**WEST SUSSEX COUNTY COUNCIL
COUNTY HIGHWAYS CONSULTATION RESPONSE**

SUBJECT: AW/43/18/OUT - Outline applicaiton with some matters reserved for the demolition of existing dwelling & erection of two pairs of semi-detached houses & associated works - More information.

261, Aldwick Road, Aldwick, PO21 3QU

1060/DPA04

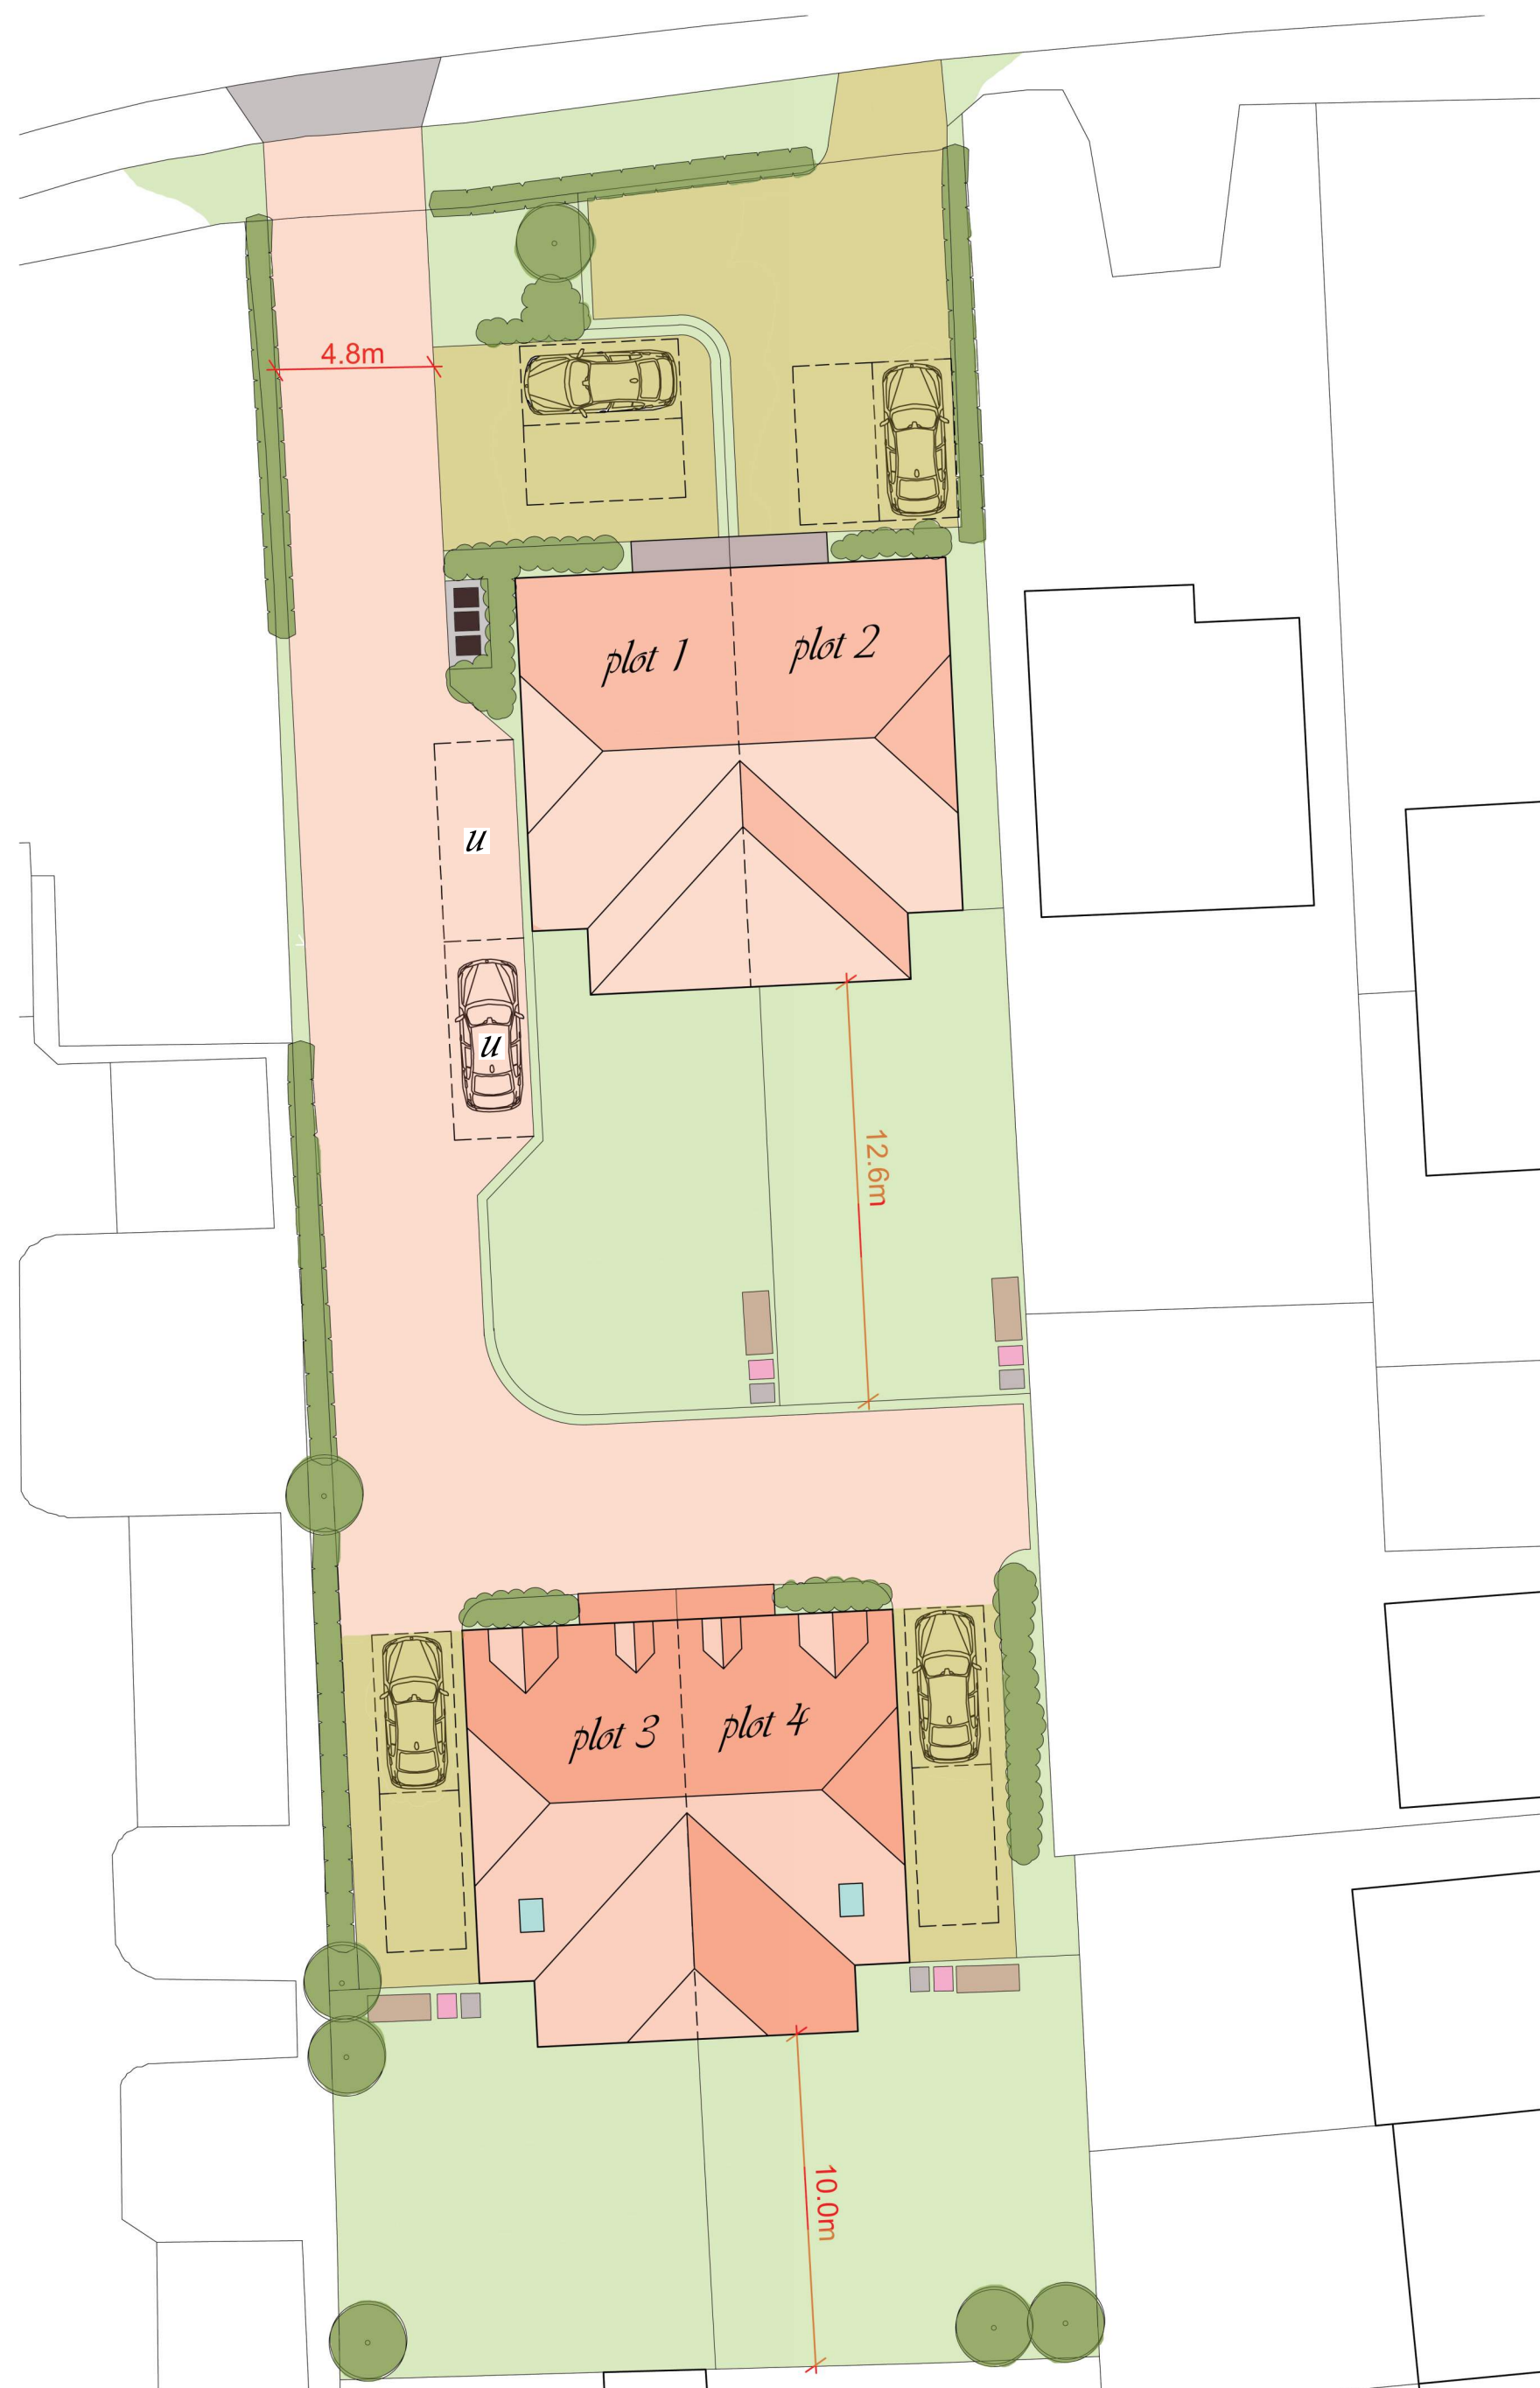
The eastern point of access will be retained to serve plot 2

The western point of access will be widened to 4.8 metres to allow access to plots 1, 3 and 4.

There appears to be no apparent visibility issues at the points of access onto Aldwick Road and adequate visibility is available using land considered to be public highway.

No highway concerns would be raised to the proposed access arrangements. The access widening works must be implemented under licence to a specification obtained from WSCC Highways.

Plots 3 and 4 will be located circa 50 metres from the public highway. For building regulation purposes the following is required:

- 3.7 m carriageway (kerb to kerb) is required for operating space at the scene of a fire.
- Simply to reach a fire, the access route could be reduced to 2.75 m over short distances, provided the pump appliance can get to within 45 m of dwelling entrances;
- Fire service vehicles should not have to reverse more than 20 m.

No swept path tracking has been provided demonstrating how an emergency tender can turn on site. I have consulted with the WSCC Fire Access Officer on this aspect of the application and will provide additional advice in due course.

It appears that a collection arrangement in line with these requirements can be achieved with a refuse vehicle remaining on Aldwick Road. Nevertheless it would be

advised that the refuse collection authority should be consulted to ensure the suitability of such an arrangement. If a refuse vehicle is required to enter the site, this must be supported with swept path tracking at the Outline Stage.

No part of the development shall be first occupied until such time as the vehicular access serving the development has been constructed in accordance with the approved drawing.
